From: [REDACTED]
Sent: 09 February 2017 09:28
To: Planning.Responses
Subject: Site: 1 Sea Drive, Ferring BN12 5HD.

Your Ref
FG/198/16/PL
Our Ref
PLAN-016922
Date
08/02/2017

Proposal: Demolition of existing house with erection of 2 storey building comprising of 8No. residential 2 bedroom flats & associated external works
Site: 1 Sea Drive, Ferring BN12 5HD.
FG/198/16/PL

DWG: PROPOSED SITE PLAN

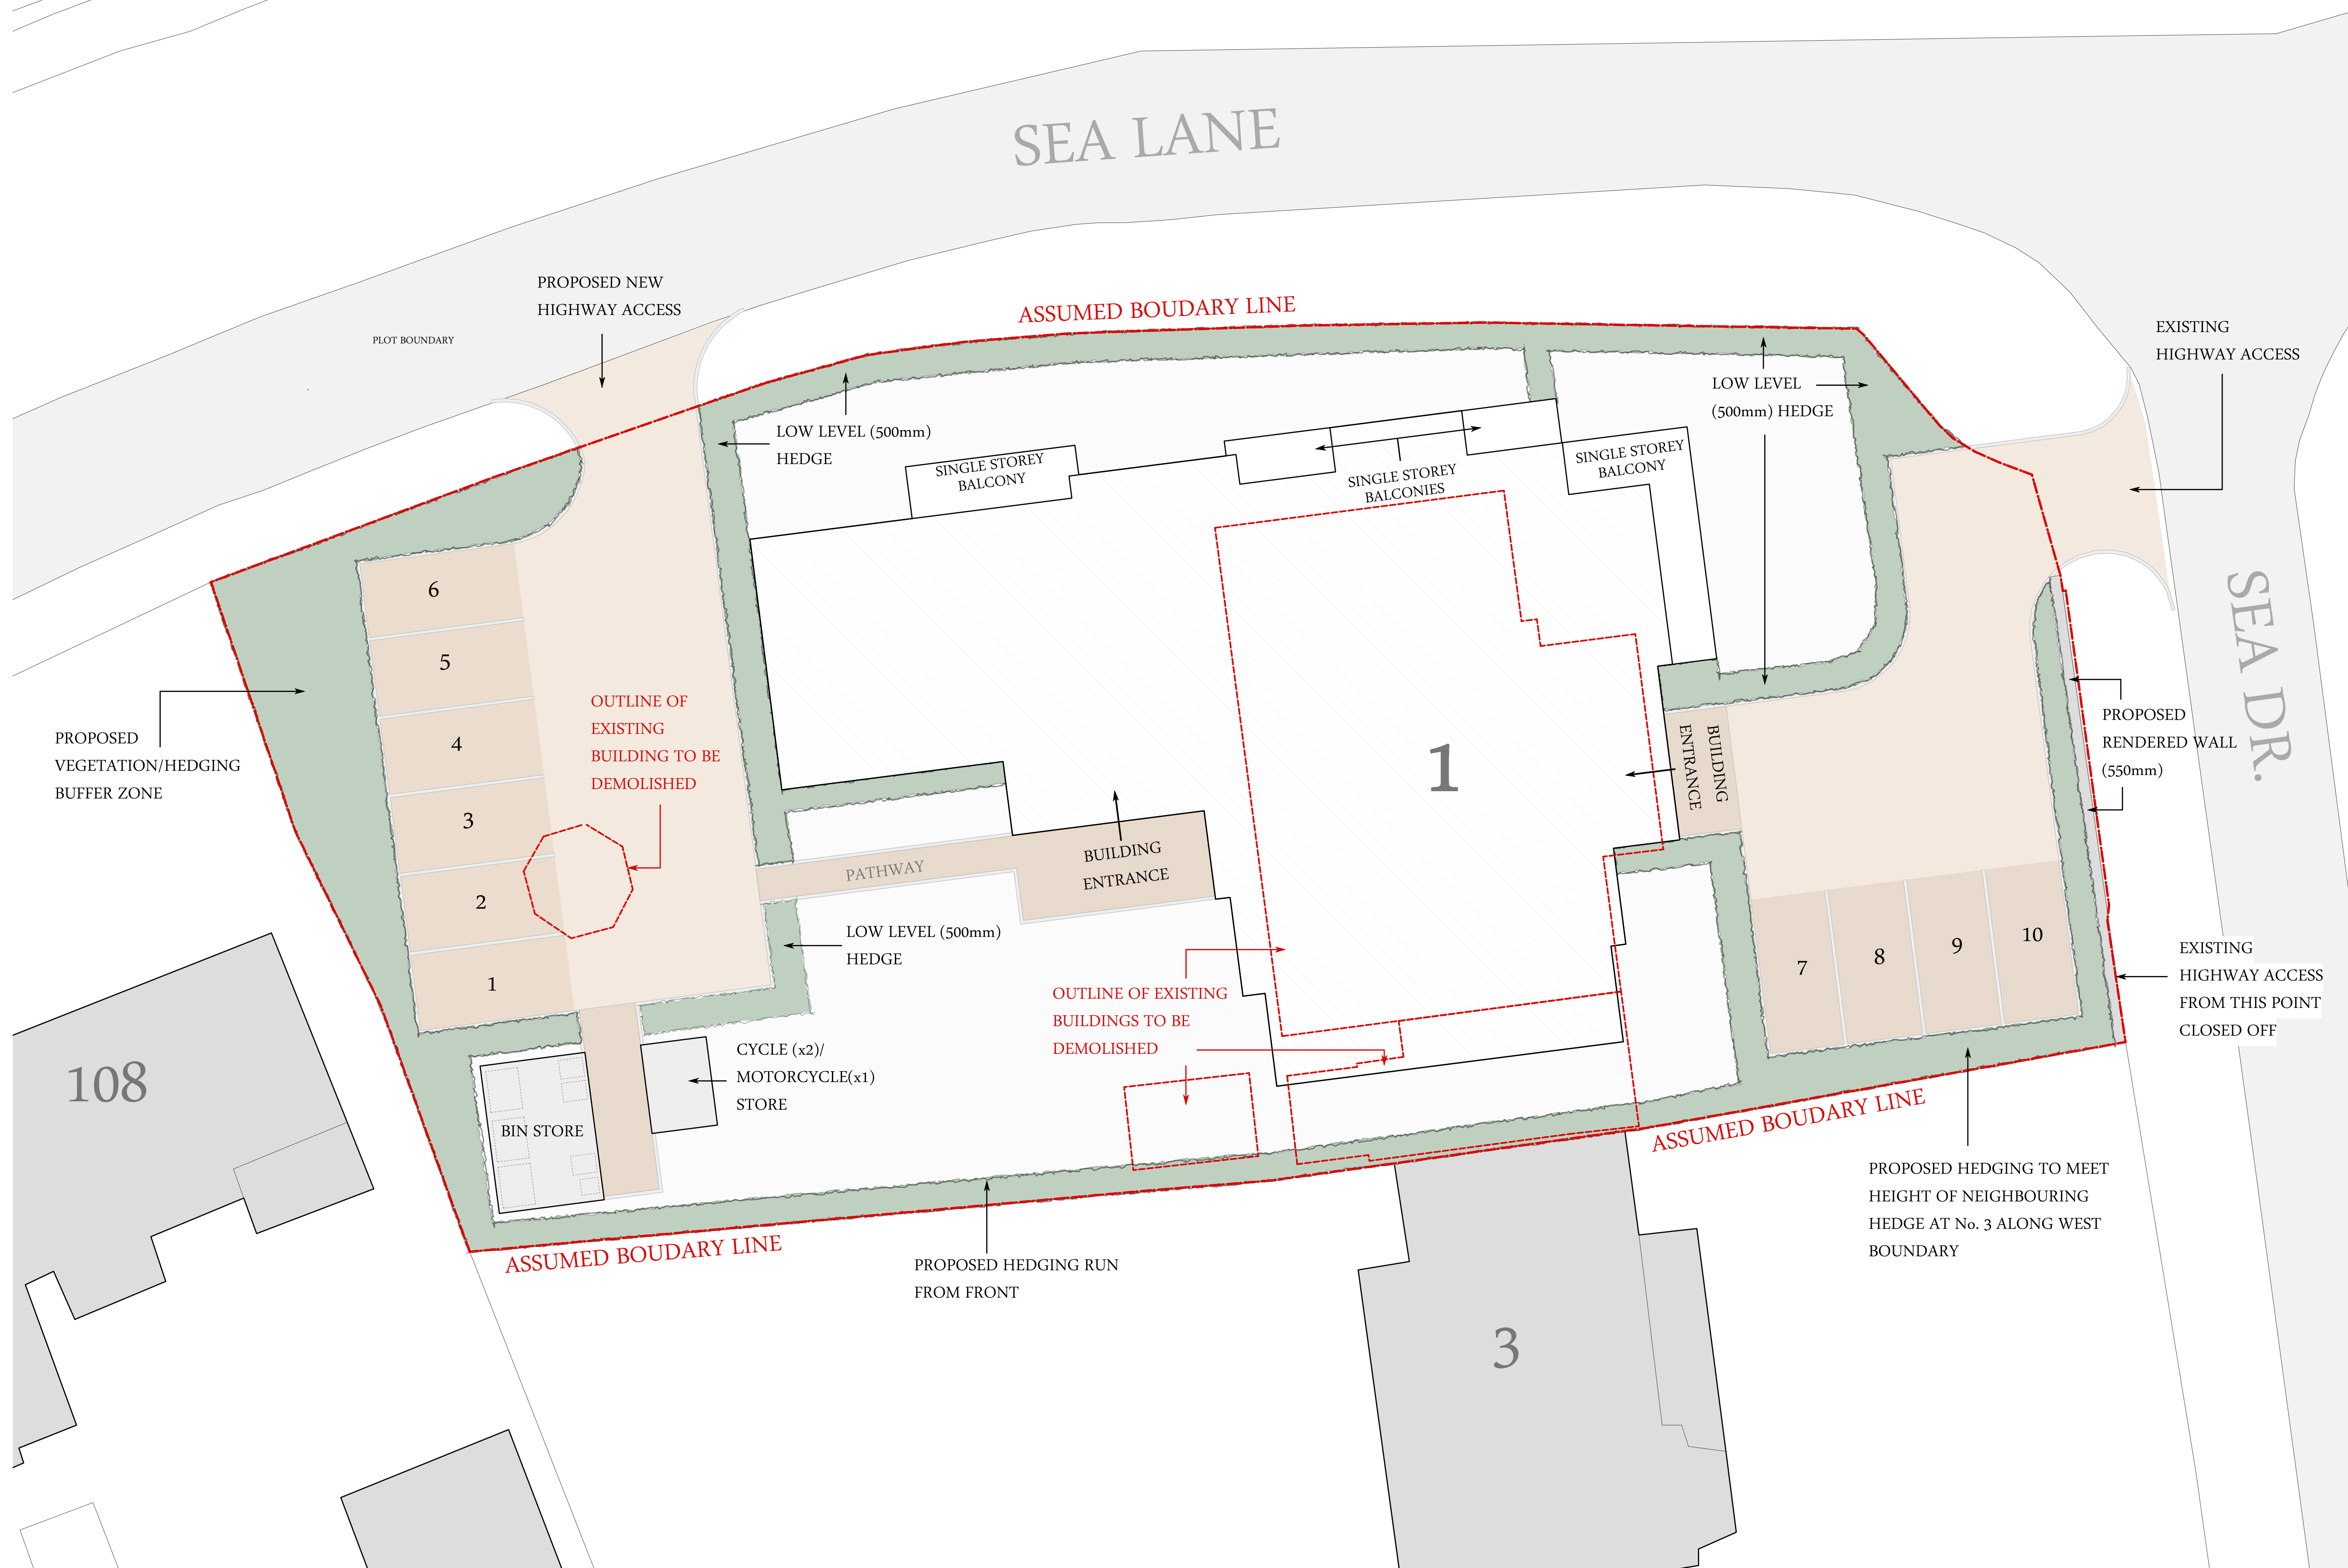
Please note there is a public foul anti flood defence (AFD) valve within the site. No construction, or development should be located within 3 metres in radius of the Southern Water foul (AFD) valve. All existing infrastructure should be protected during the course of construction works.
